**KIRKLEES METROPOLITAN COUNCIL
INVESTMENT & REGENERATION SERVICE**

Reference No:	2023/62/92608/W
Site Address:	Carr Lea House, 56, Rawthorpe Lane, Dalton, Huddersfield, HD5 9NU
Description:	Change of use from one dwelling to two dwellings
Recommending Officer:	William Simcock

DECISION – Conditional Full Permission

Officer Report – 2023/92608

DIMENSIONS IN mm – IF IN DOUBT ASK – DO NOT SCALE

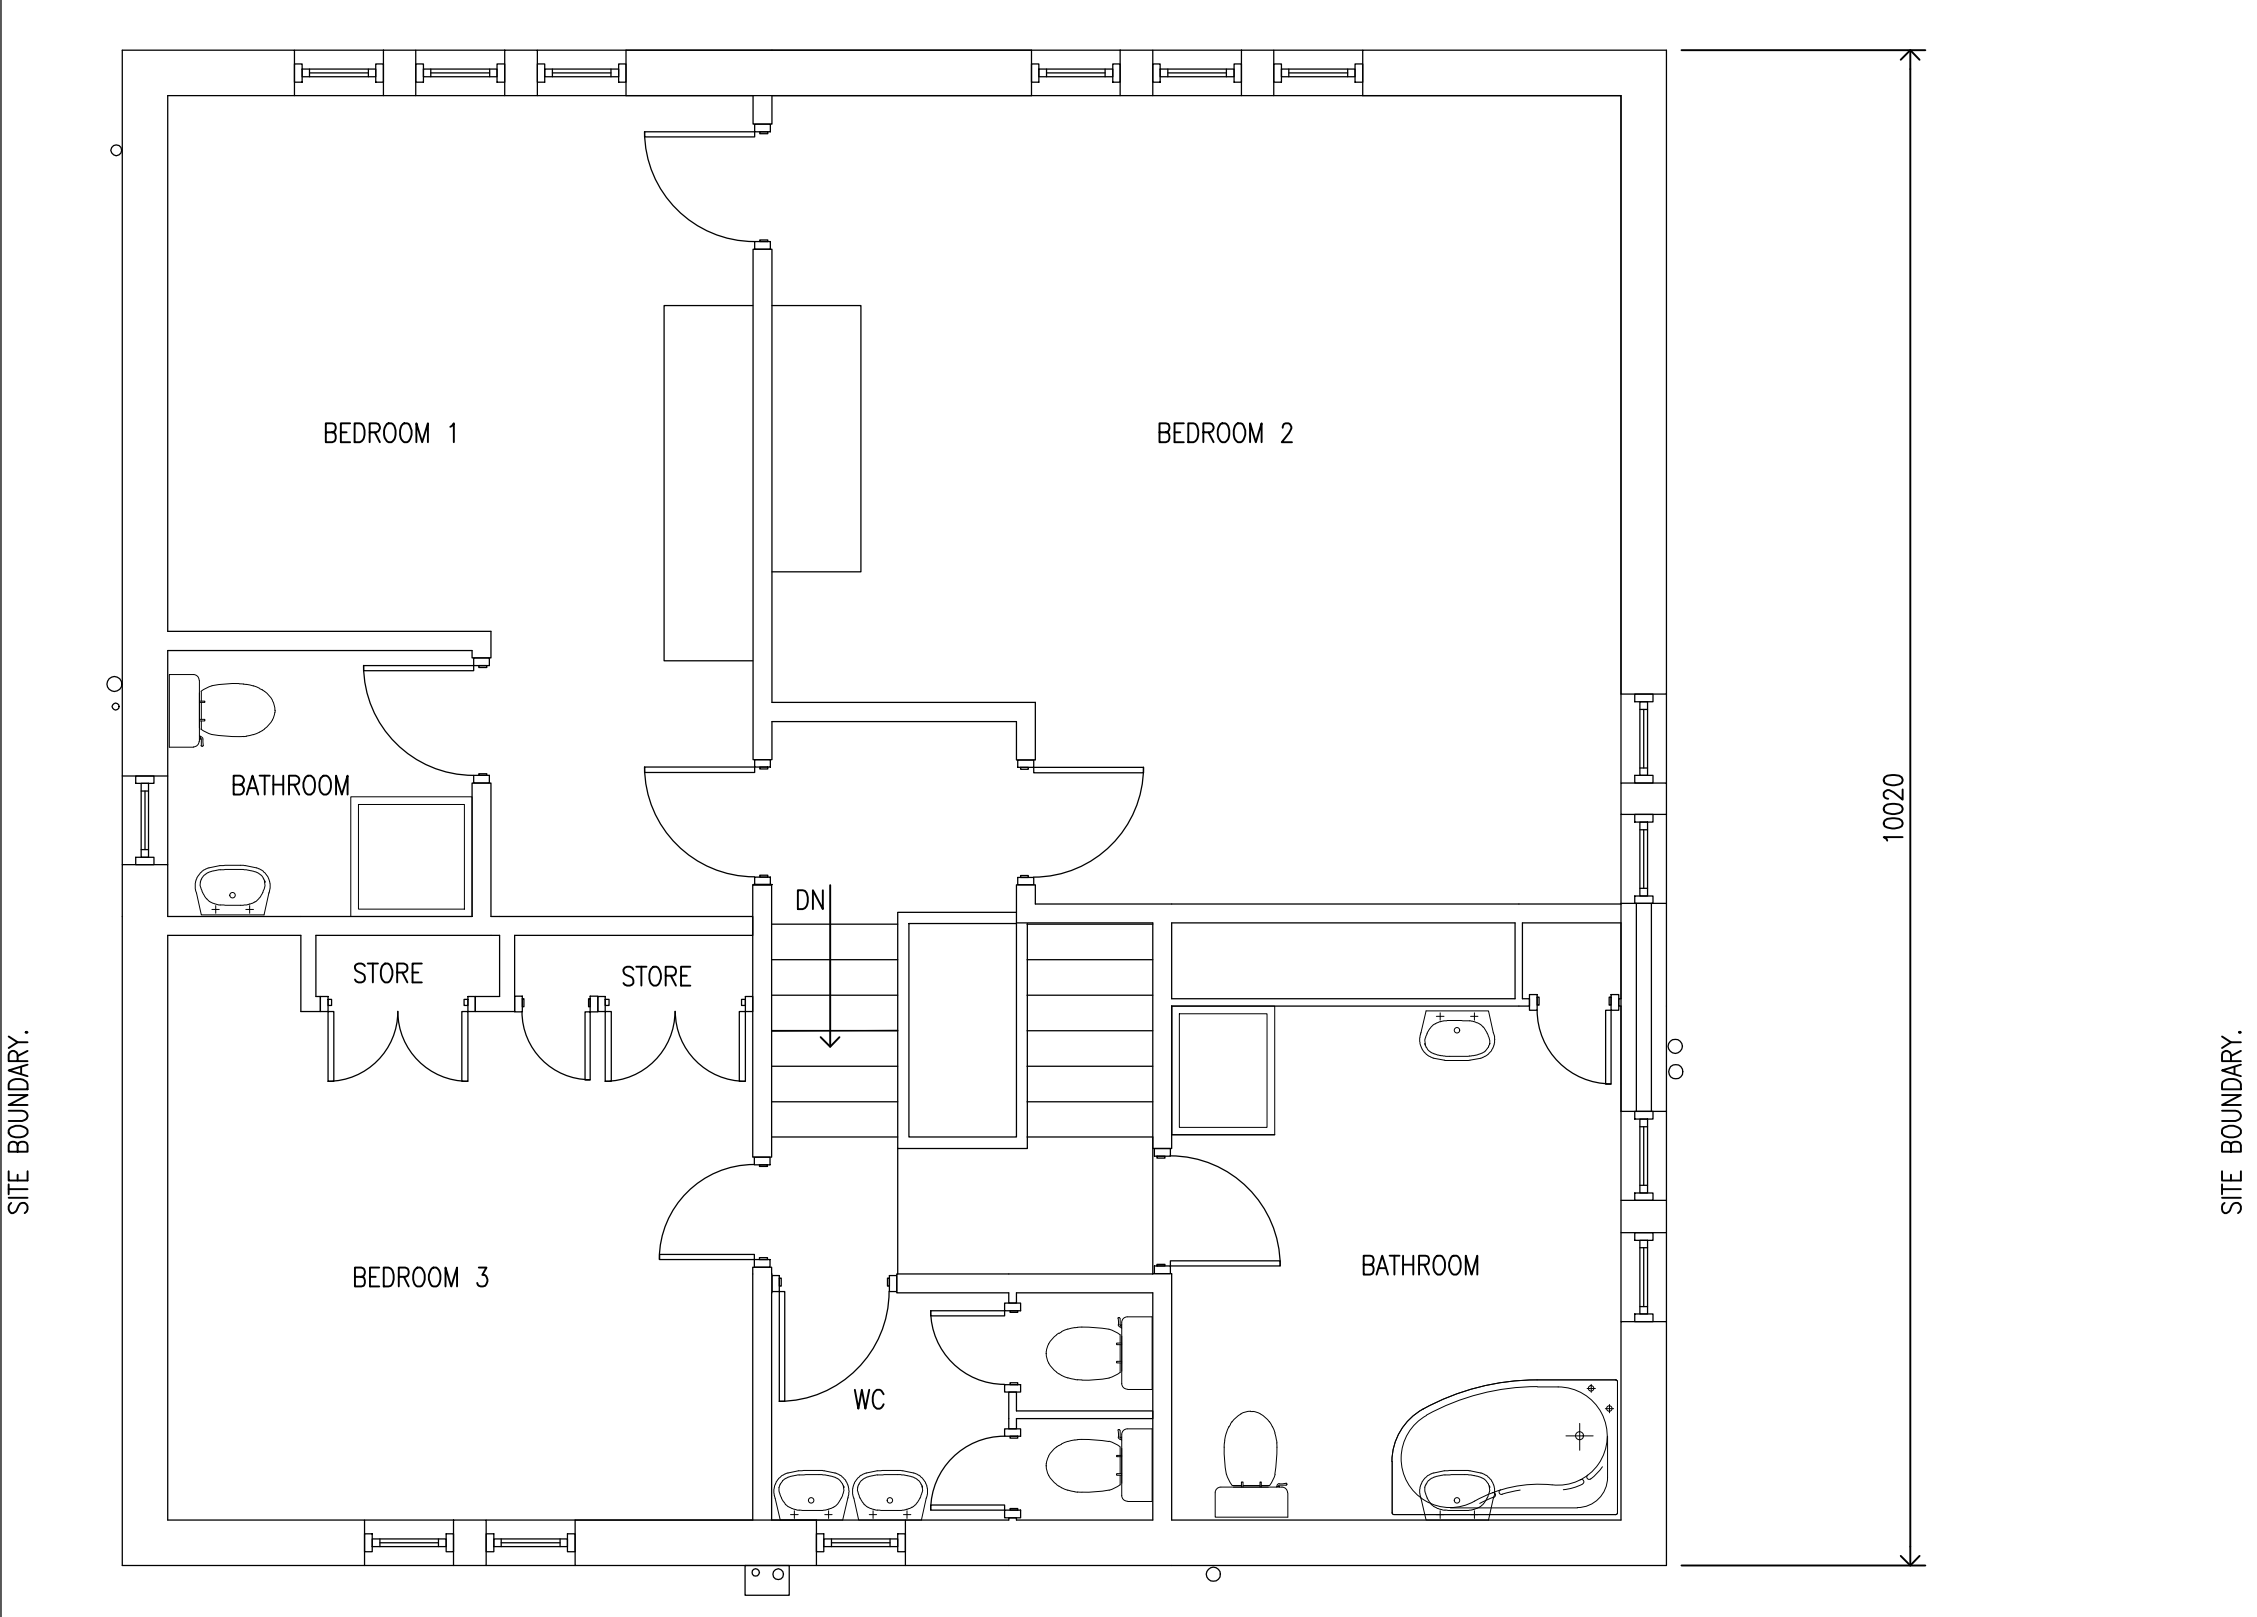
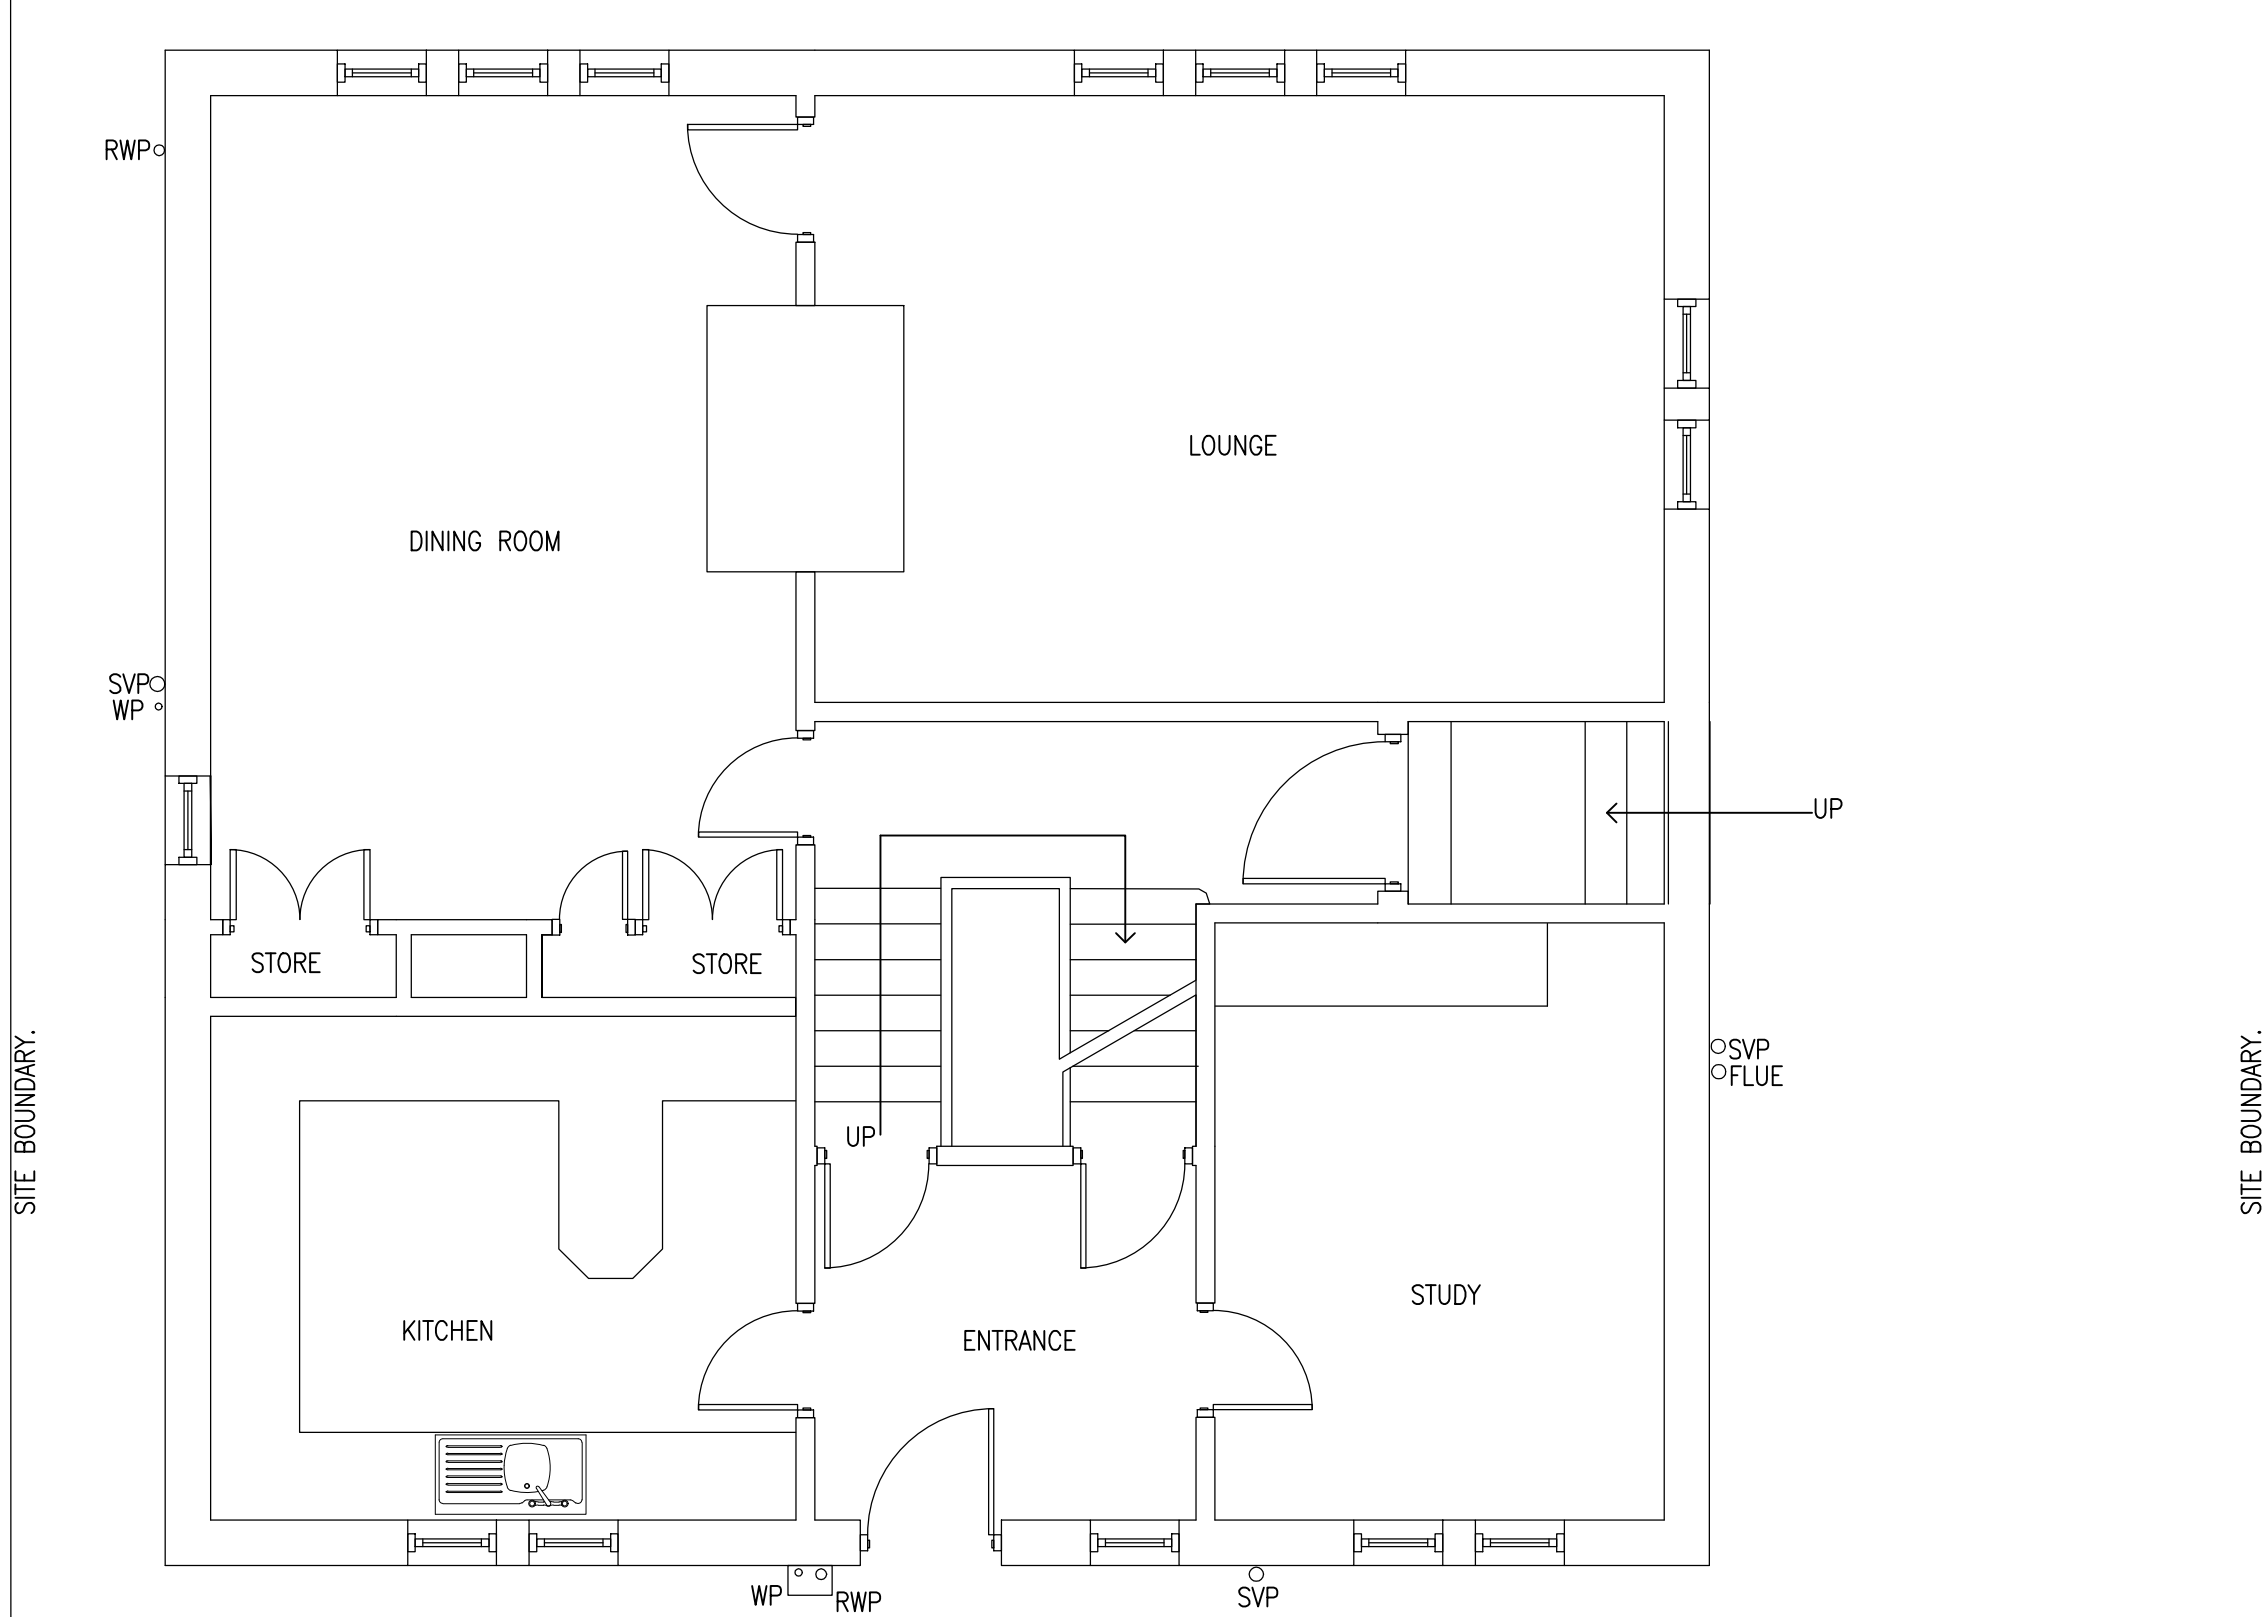
- A single-storey, single-bedroom dwelling occupying roughly half the ground floor, area 50sqm;
- A two-storey dwelling comprising a living room at ground floor rear, four bedrooms and a dining kitchen above, of approximately 104sqm floorspace.

A new entrance door would be installed in the front elevation to allow access to the storage room. The existing front and side doors would become the entrance doors to the two new dwellings.

Floor space for each dwelling would be in excess of the minimum required by the NDSS. It is considered that all habitable room windows in the two-storey dwelling would have an adequate outlook and receive acceptable amounts of natural light.
